Our ref: HA/2019/121744/02-L01
Your ref: ENVPAC/1/SSD/00112
Date: 28 November 2019

DETAILED ADVICE: DEMOLITION OF 1 NO. EXISTING DWELLING & ERECTION OF 1 NO. NEW DWELLING

ATHERINGTON LODGE CLIMPING STREET CLIMPING BN17 5RN

LONG SECTION AA

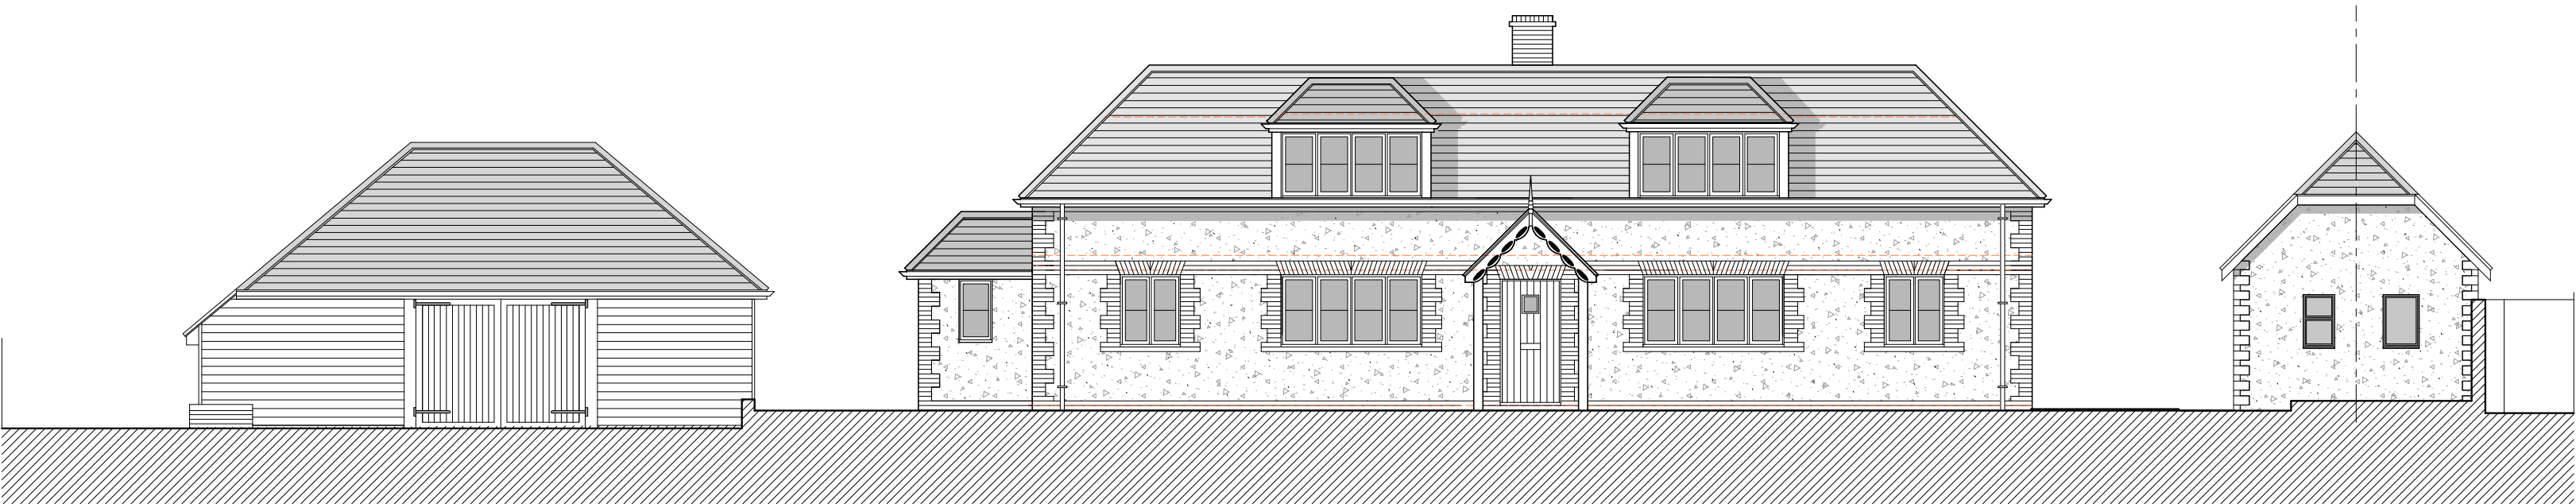
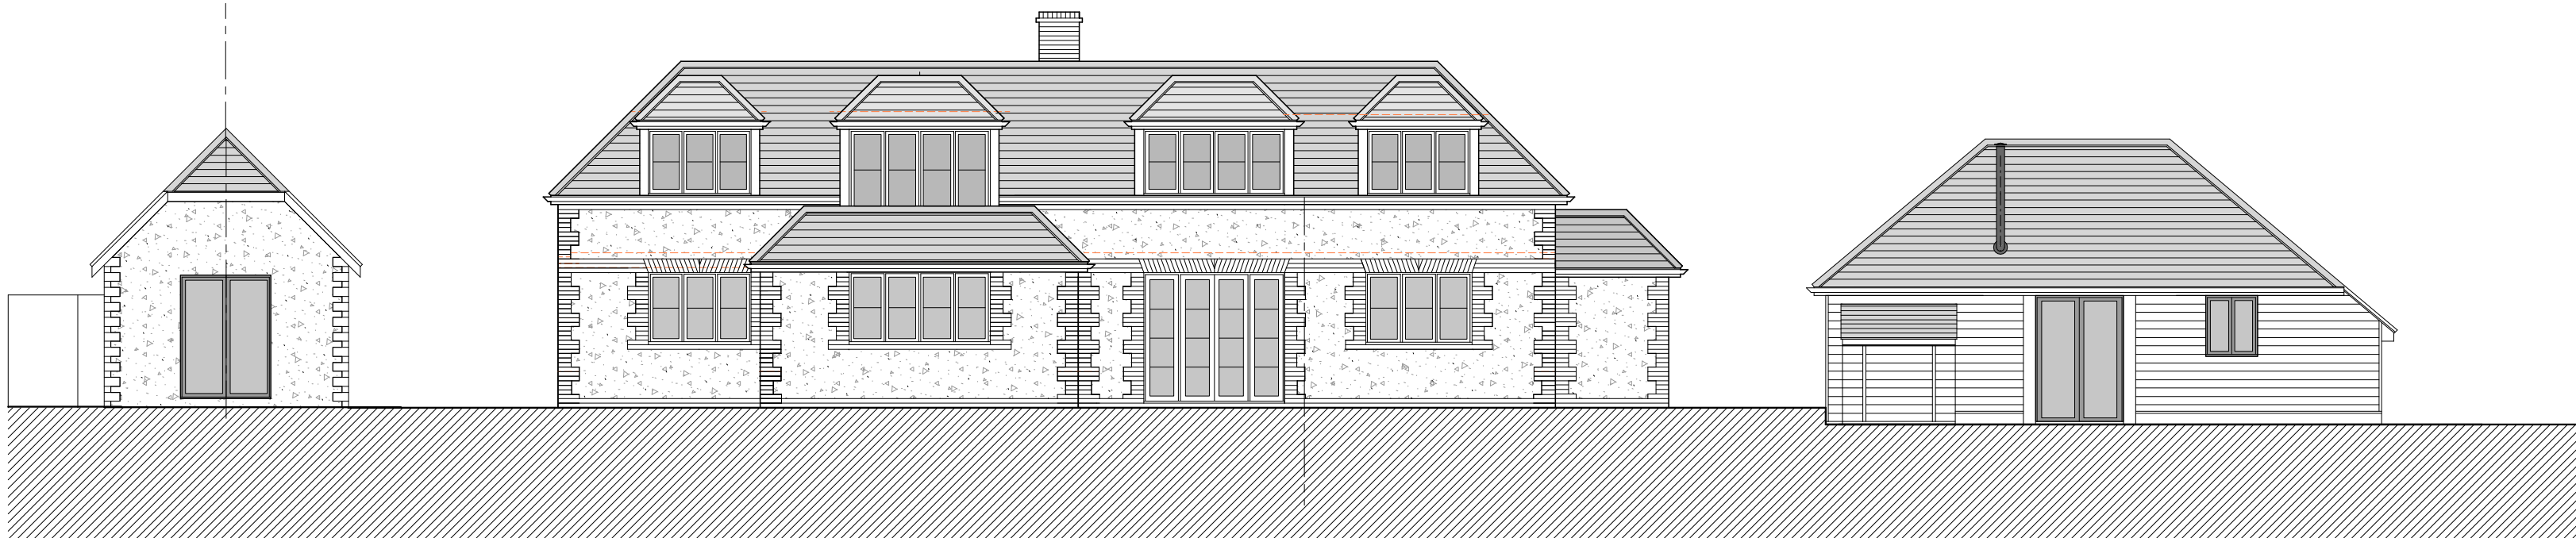
Although this is a replacement dwelling we would strongly recommend that finished floor levels (FFL) are raised at least 300mm above ground levels. The FRA states that FFL will be retained as existing, but nowhere mentions what the existing floor levels are and if these are raised above ground levels. We would recommend this is clarified within the FRA. This is particularly important when considering sea level rise and long term climate change effects on our coastline.

It is good to see that all bedrooms will be located on the first floor. Also safe refuge on first floor is mentioned in the FRA, but no levels for the first floor are given. Therefore it is not possible to establish if first floor levels are above 5.04m AOD, which is the undefended 0.5% AEP 2115 events. The FRA should make this clear. In Section 15 of the FRA (Conclusion and Recommendations), the statement 'The EA considers the sites overall flood risk to be low' should be removed. How can it state that when the EA Flood Map for Planning (Rivers and the Sea) shows the site to be in Flood Zone 3 (high risk)?

To overcome our objection, the applicant should submit a revised FRA which addresses the points highlighted above.
